December 2, 2016

SUBJECT: **Modification Request of Section 404 Regional General Permit No. 31 and Section 401 General Water Quality Certification No. 3886** for the proposed Interstate 85 (I-85) Widening and Interchange Improvements from north of NC 73 (Davidson Highway / Exit 55) to north of SR 2180 (Lane Street/Exit 63), Cabarrus & Rowan Counties, Divisions 9 and 10. Federal Aid Project No. FANHIMF-085-2(61)55, TIP Project No. I-3802A.

The permit drawings for these three sites have been revised to depict the additional bank stabilization at Site 2, temporary impacts at Site UC-1, and the additional bank stabilization at Site 18. They have been included in this modification request along with the revised impact summary tables.

PROJECT REFERENCE NO. I-3802A	SHEET NO. 22
RW SHEET NO.	
ROADWAY DESIGN ENGINEER	HYDRAULICS ENGINEER
BLYTHE

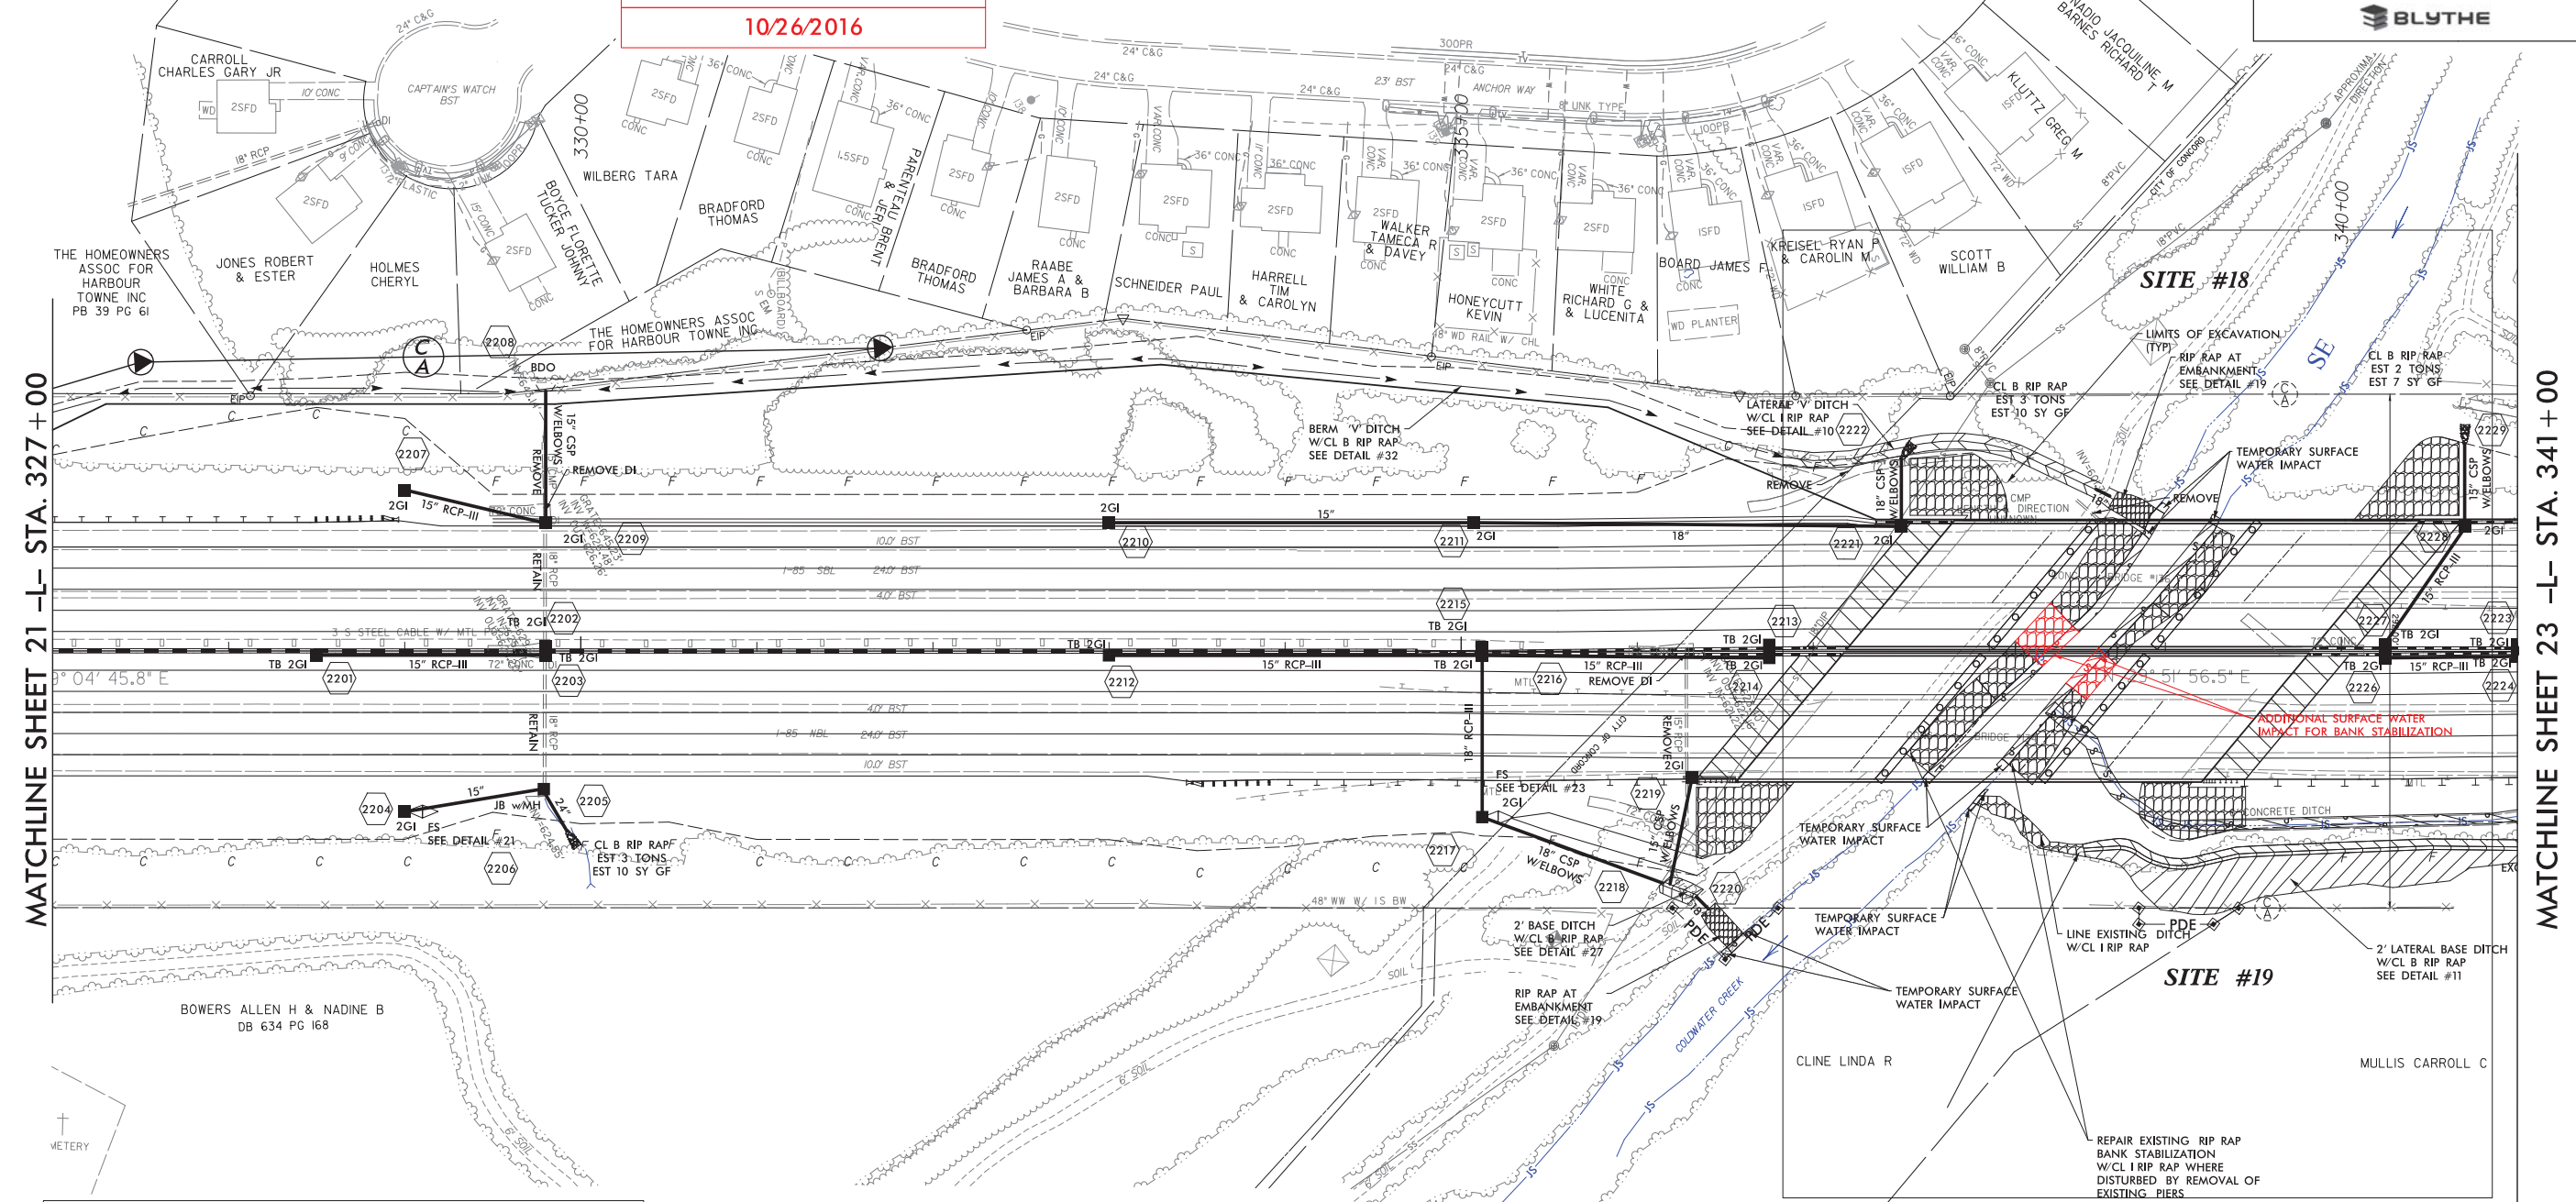
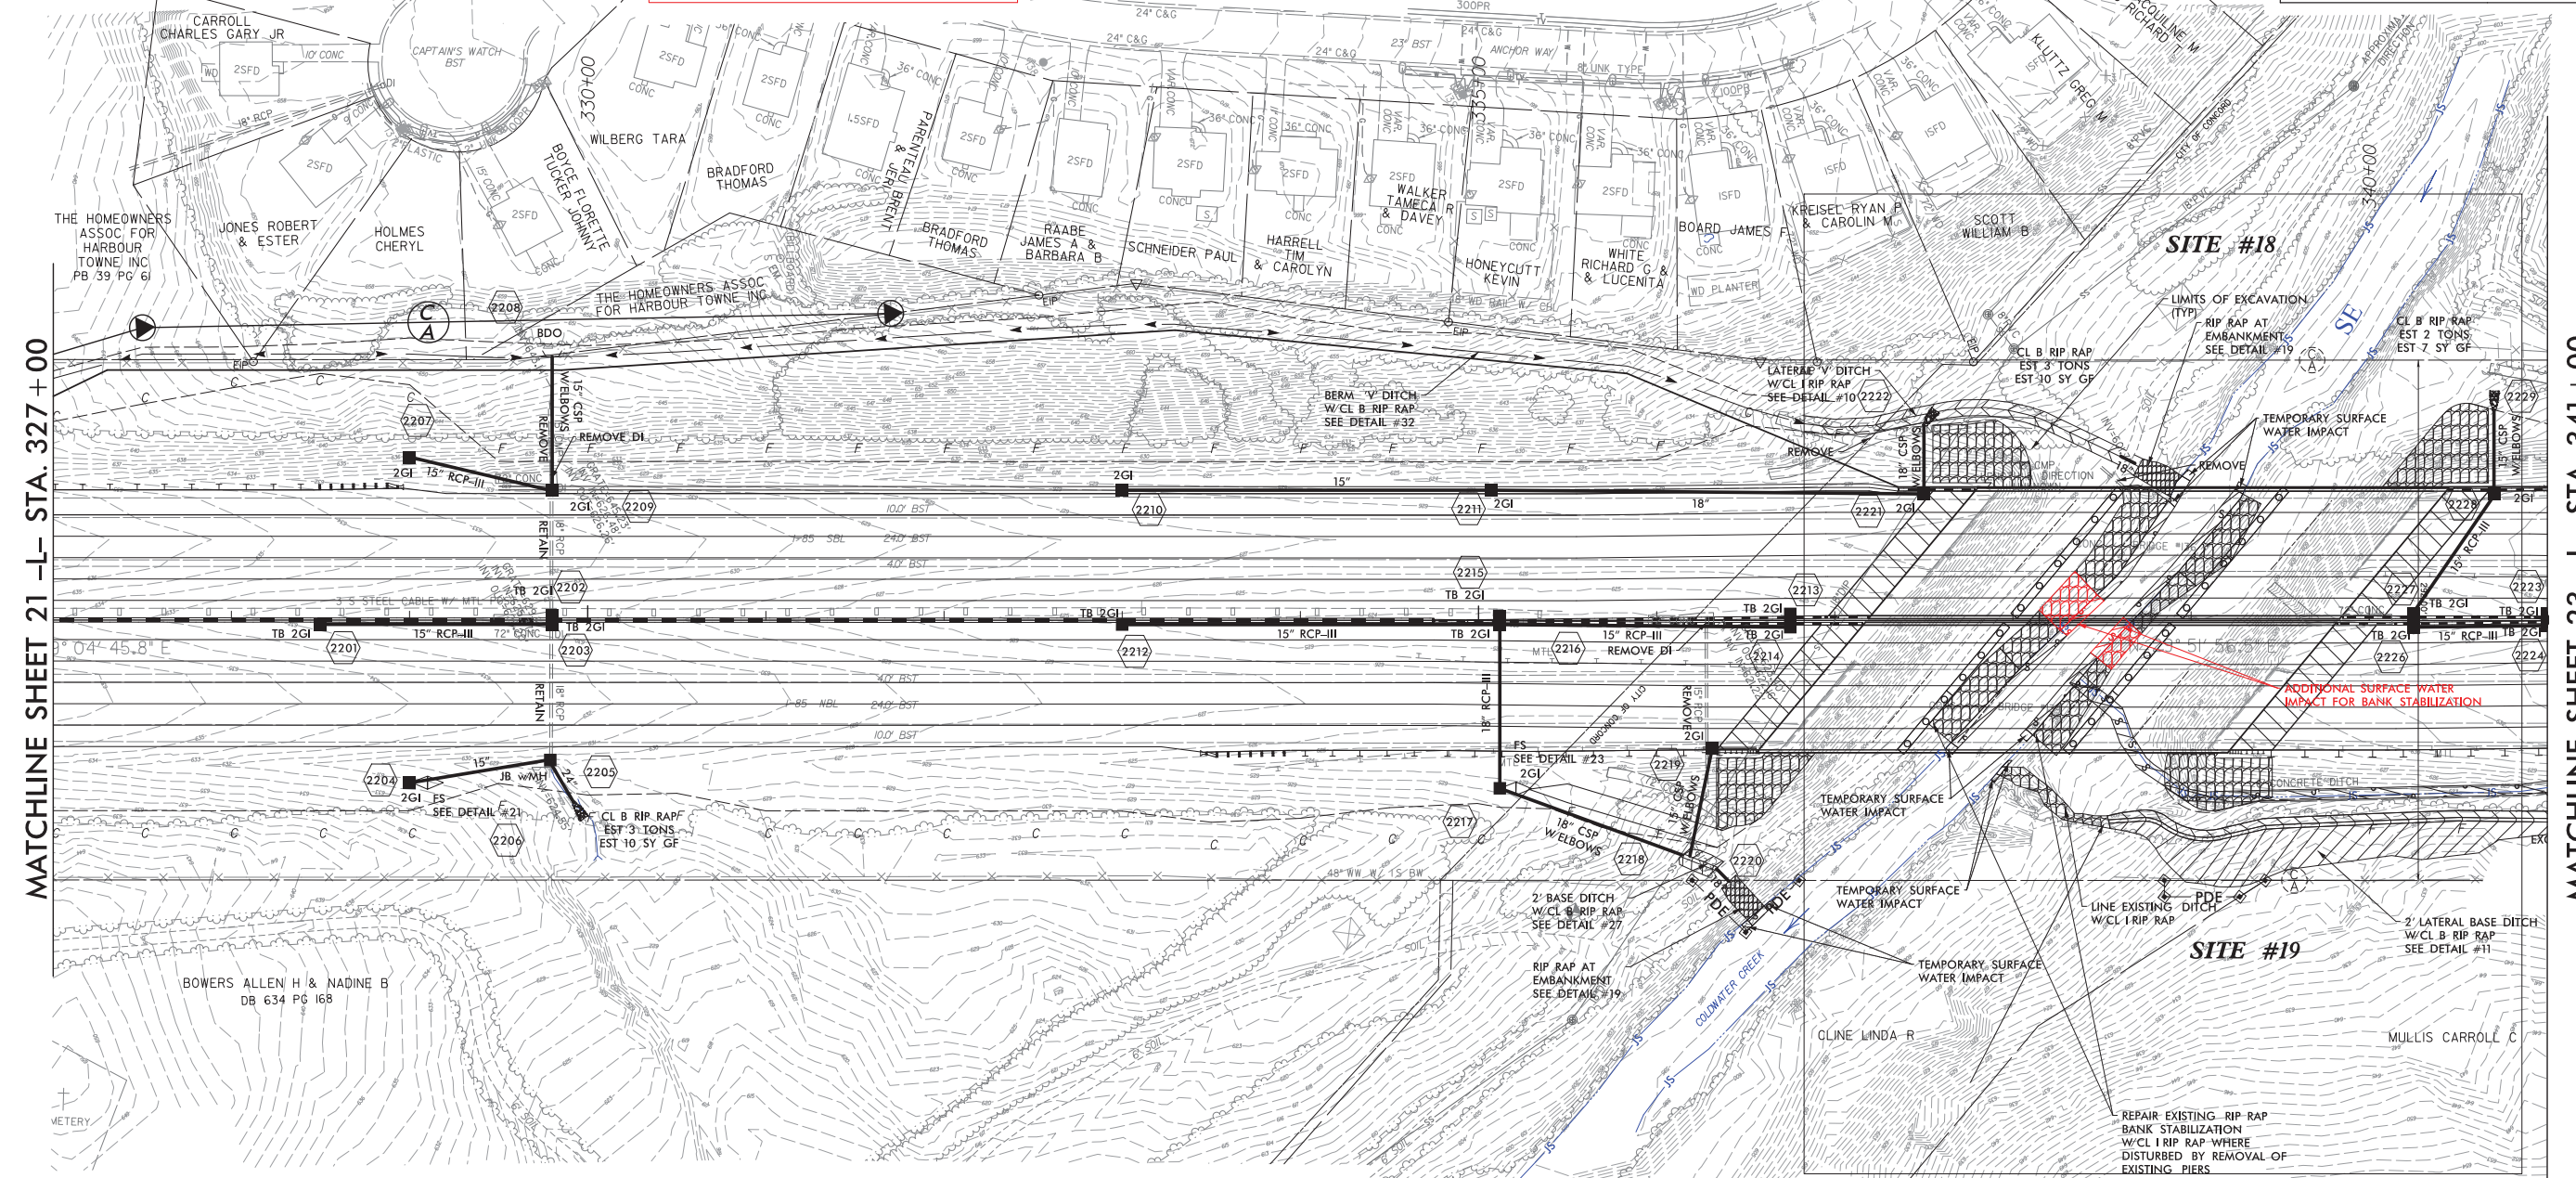
On November 17, 2015, representatives from NCDOT met on site with Ms. Donna Hood (N.C. Division of Water Resources [NCDWR]) to conduct a project review. During the site meeting Ms. Hood recommended that additional riprap be placed under the Cold Water Creek Bridge. The contractor also required a temporary crossing at the same

location. A modification request for the addition of 66 linear feet of temporary stream impact due to the placement of the temporary causeway and 30 linear feet of permanent impact due to bank stabilization at Site 18 was initially requested on February 18, 2016. The modification to the Section 401 certification was approved by NCDWR on March 22, 2016. The Section 404 modification request has not yet been approved by the U.S. Army Corps of Engineers (USACE). Since the February submittal, it has been determined that the temporary crossing is no longer needed. Additionally, the riprap bank stabilization was installed at the site by the contractor prior to receiving the USACE permit modification, most likely due to a misunderstanding that both the Section 404 and 401 modifications had been approved. The previously approved 185 linear feet of stabilization, which was permitted by the original permit, and the additional un-permitted 30 linear feet included in the last permit modification request has already been installed at the site.
